**Our Case Number:** ABP-318446-23

**Re:** Proposed construction of Coumnagappul Wind Farm consisting of 10 no. turbines and associated infrastructure.  
In the townlands of Coumnagappul, Carrigbrack, Knockavanniamountain, Barricreemountain Upper and Glennaneanemountain, Skeehans, Lagg, Co. Waterford.  
([www.coumnagappulwindfarmSID.ie](http://www.coumnagappulwindfarmSID.ie))

***An Bord Pleanála Case reference: PA93.318446***

***Proposed construction of Coumnagappul Wind Farm consisting of 10 no. turbines and associated infrastructure.***

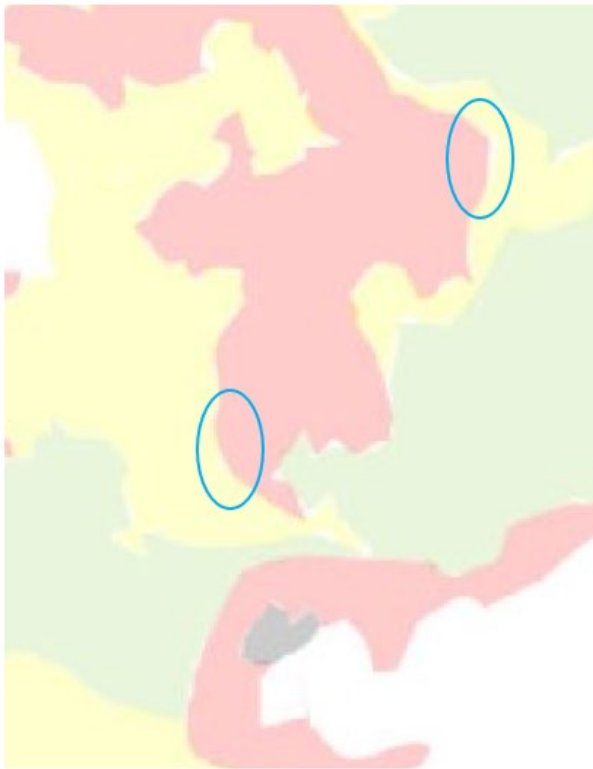
The subject site is on an area classed as an exclusion zone for Wind Farm Development per the Waterford City and County Development Plan 2022-2028. This Development Plan was adopted on Thursday July 7<sup>th</sup>, 2022, by a unanimous decision of the Council and came into effect on July 19<sup>th</sup> 2022. This Plan was made following lengthy periods of consultation, drafting and deliberation. It involved 5 rounds of public consultation. The Plan was then approved by both the Planning Regulator and the Minister for Housing, Local Government and Heritage. This being the relevant statutory development Plan applying to the subject site in question and as such must be central to making a decision.
